Development Control
Ribble Valley Borough Council

App no: 24.0726

Address: Shackletons Garden Centre Clitheroe Road Chatburn

Proposal: Approval of details reserved by conditions 4 (construction management/method), 5 (site access and off site works of highway mitigation), 11 (car park surface water drainage), 17 (surface water drainage) and 18 (surface water and pollution prevention) on planning permission 3/2020/0911.

Title: PROPOSED DRAINAGE GENERAL ARRANGEMENT SHEET 1 OF 2

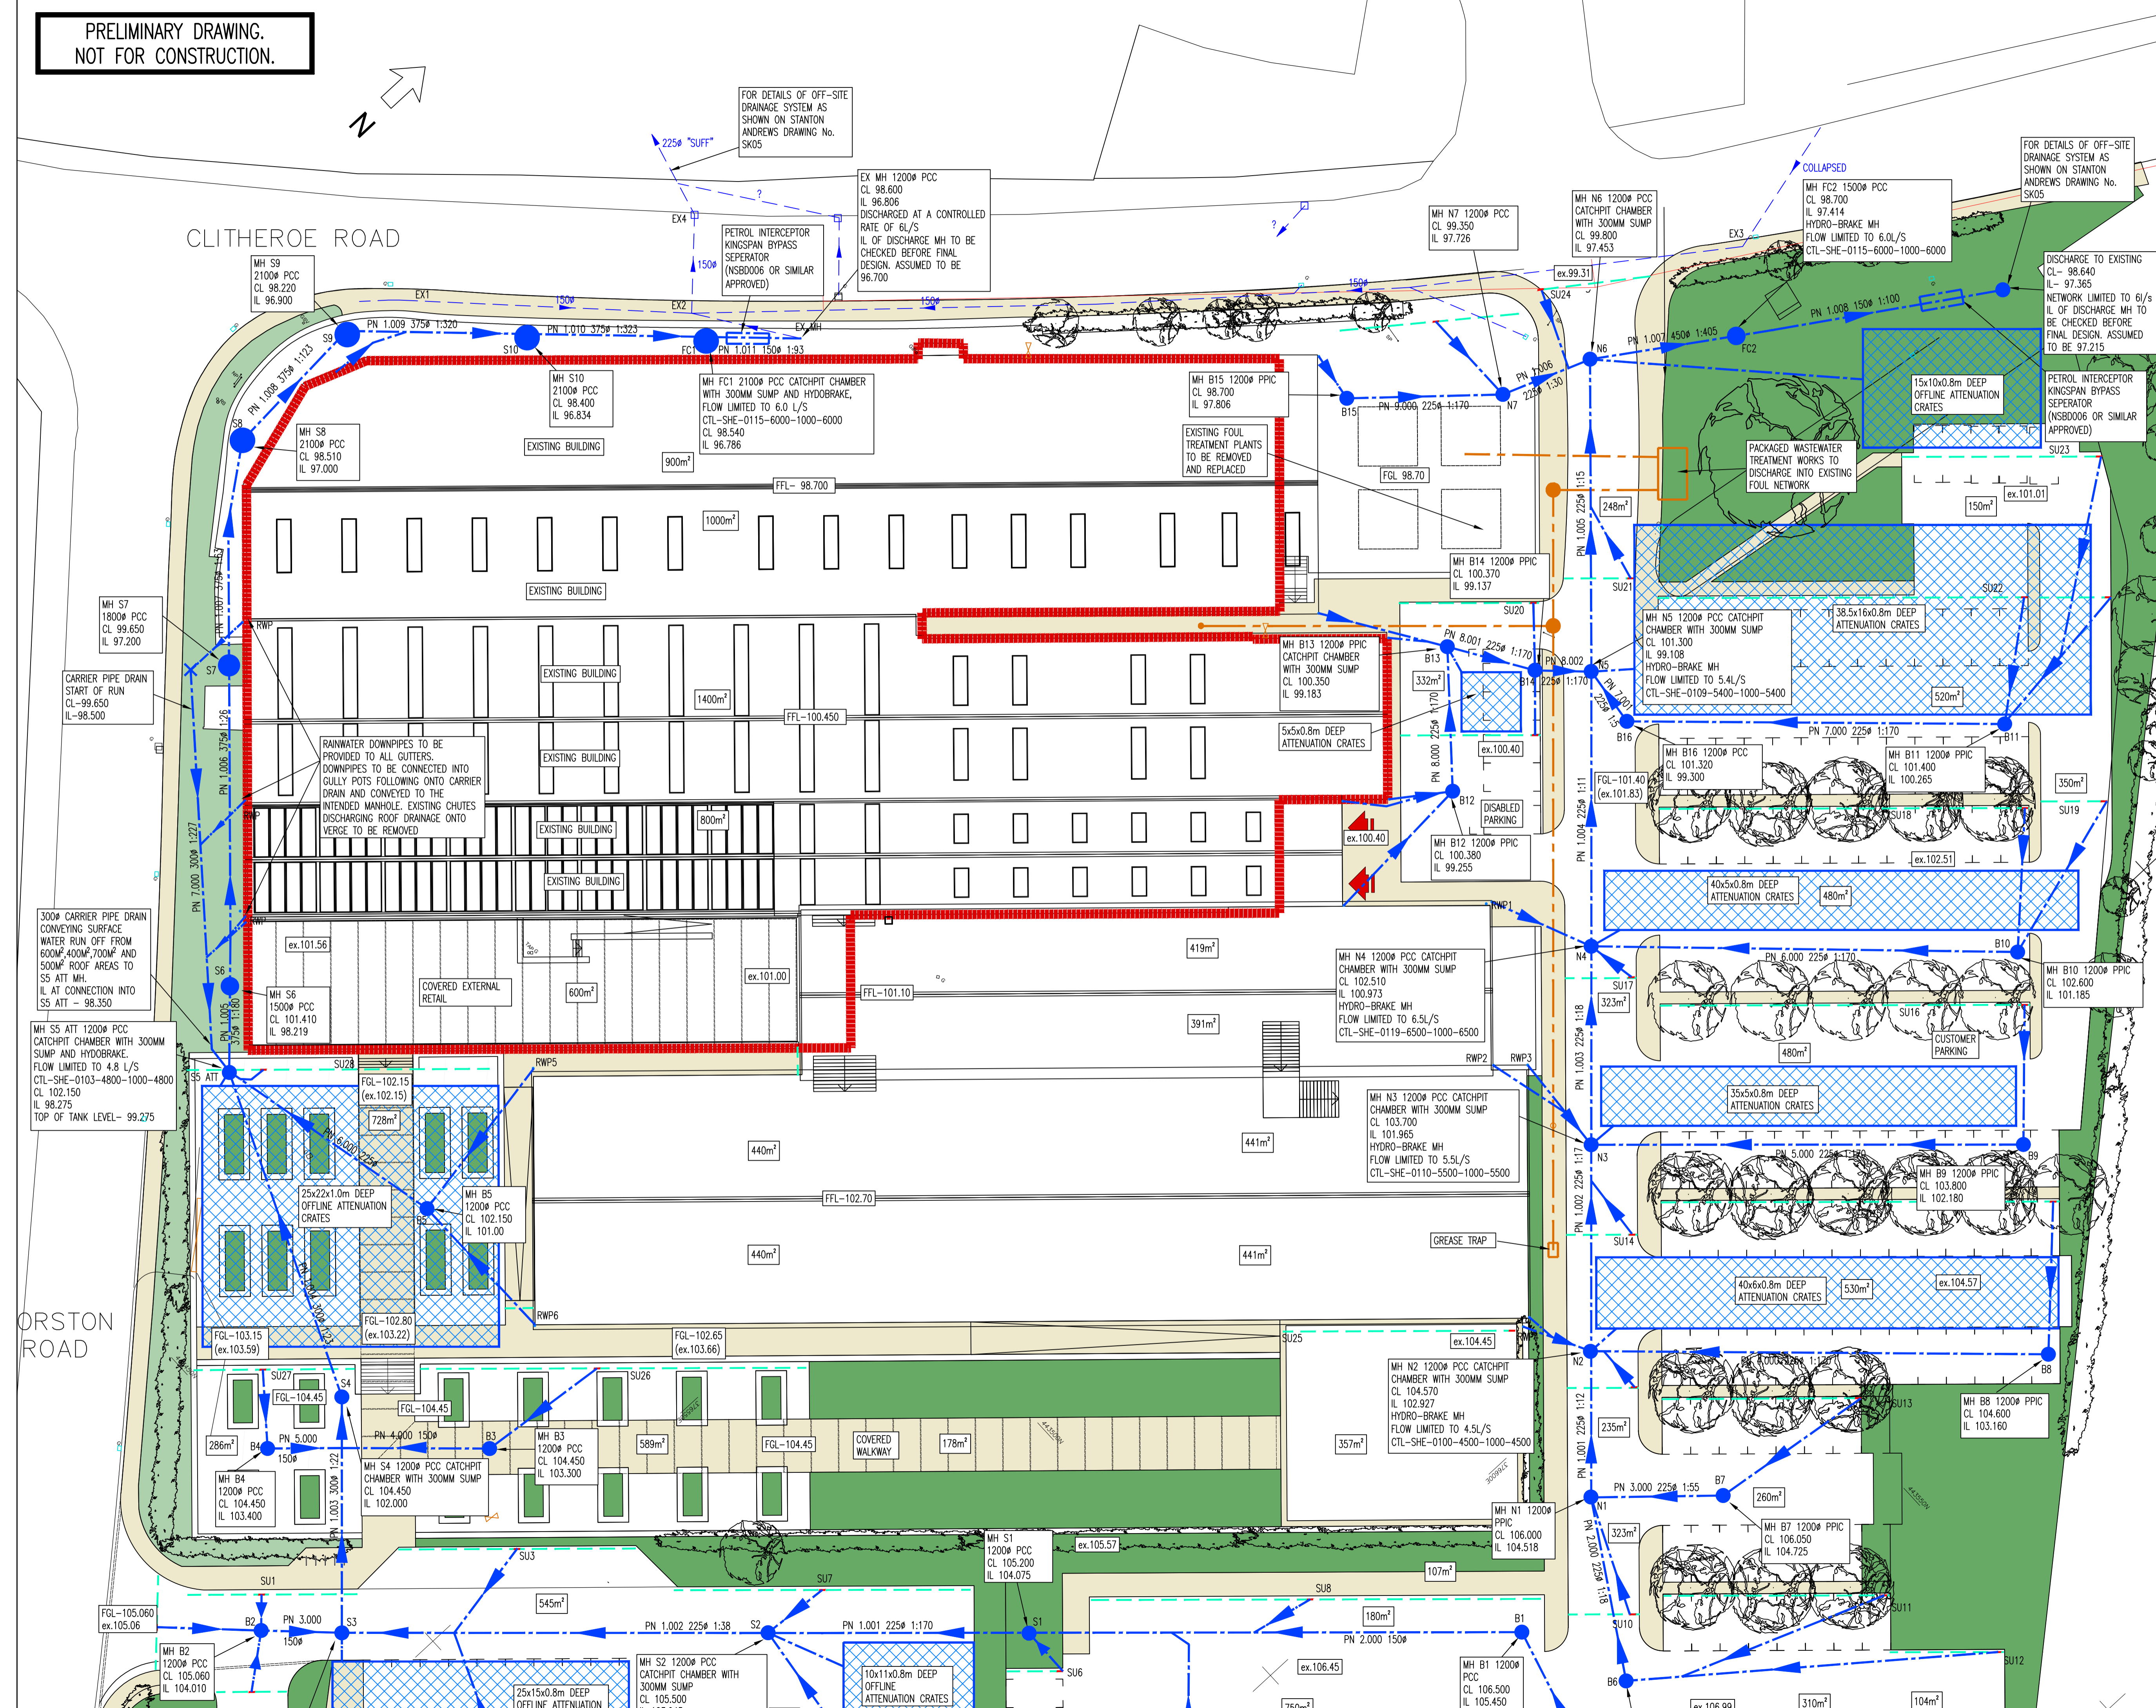
Following a long history of flooding of the highway on Clitheroe Road, in 2021 Lancashire County Council carried out an investigation and identified a blockage 5m north of manhole EX4 (manhole reference taken from drawing 'Reid Jones Partnership 10301-101-P5 Proposed Drainage GA Sheet 1 of 2'). Manhole EX4 was

full of silt. The blockage lies beneath third party land and is causing the system to silt up and flood the highway.

The site was visited again in June 2023 but the manhole EX4 was unable to be accessed due to a parked car, there was water bubbling up from the concrete yard and it was anticipated that the same problem was evident.

The surface water drainage from the site will be connected into this system.

Further evidence is needed to demonstrate, that these systems are in a sufficient condition and have sufficient capacity to accept the runoff generated by the proposed development, without resulting in an increased risk of flooding the highway.

If the previously identified blockage has not been rectified, then the proposal is likely to result in an increased risk of flooding to the highway which the Highway Authority would raise an objection to on highway safety grounds.

We would request that this condition is not discharged until the surface water drainage has been resolved.
